From: Laura Gibbons
Sent: 30 May 2018 15:49
To: Simon Davis
Subject: RE: Application AL/32/18/PL The Wolds - Drainage

From: jon [REDACTED]
Sent: 30 May 2018 11:04
To: Simon Davis
Subject: Application AL/32/18/PL The Wolds - Drainage

Typical Concrete Block Permeable Paving
Scale 1:20

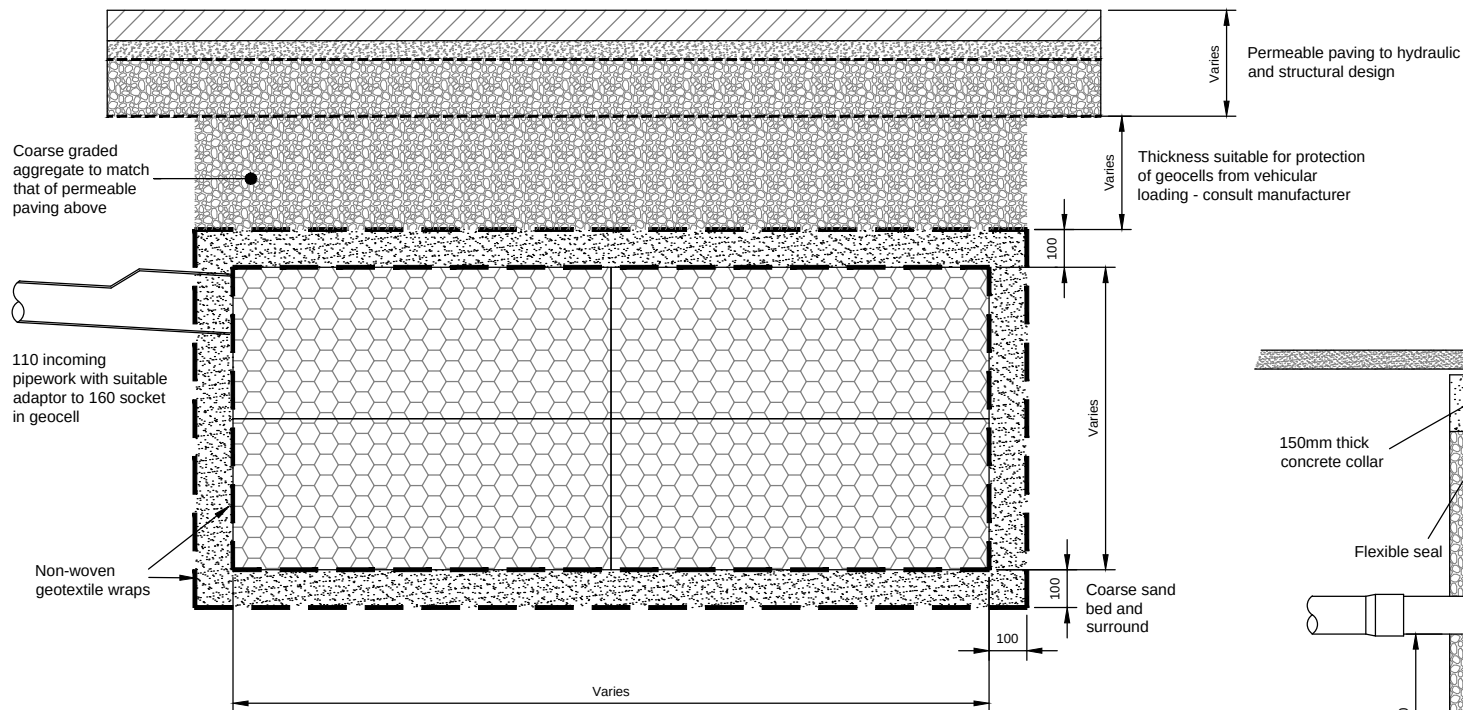
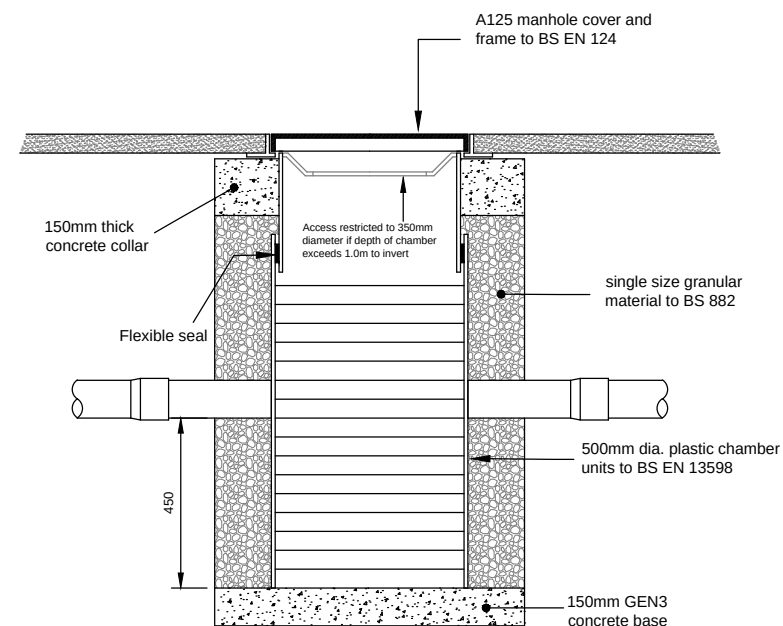
I have had a look over the supplied drainage details. The only issue which needs addressing before I am happy with the proposed is the need for the finish and formation level of the proposed permeable paving to be included on the plan.
